Roof alterations & single storey rear & infill extensions. This application affects the character & appearance of the Craigweil House Conservation Area.

14 Kingsway Aldwick

Thank you for your internet representation made on 15th June 2019 which has been recorded as '**no objection**' with the comments as follows:

south

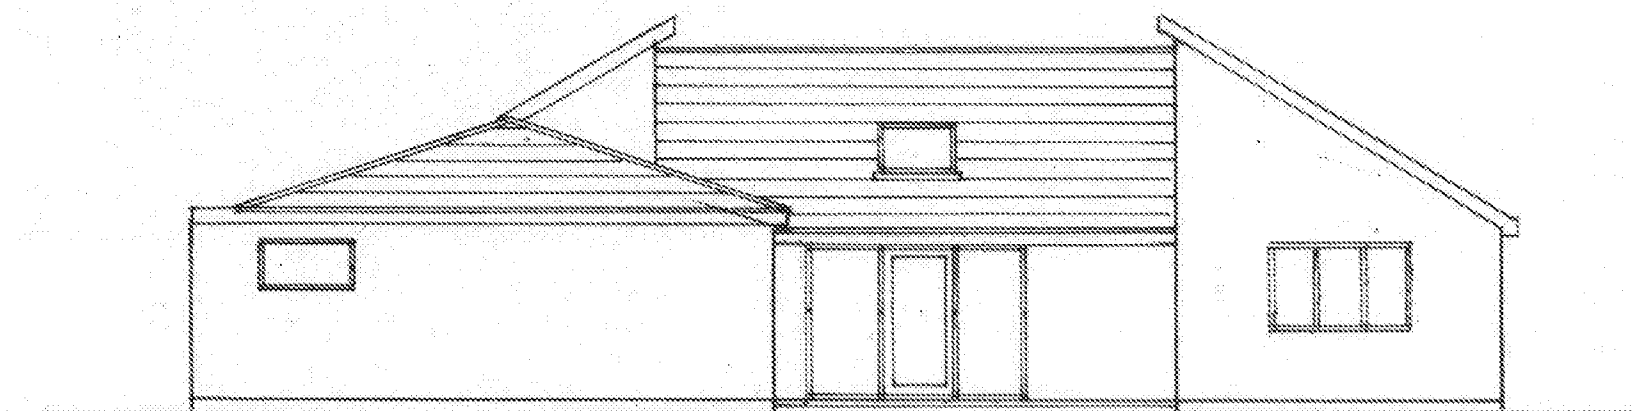
We support the proposed design and concept changes to the existing bungalow. However, we are concerned about the windows above the glazing/doors of the wings of the new elevation on the south facing side. The south elevation overlooks our property. We understand that the bungalow is to remain a single storey however the glazing as shown extends to the apex of the roof. We should be grateful if the Planning Officer could take our concerns into consideration when making a decision. We request that this area should either be white K-REND as the rest of the property or that the glazing is obscure glass.
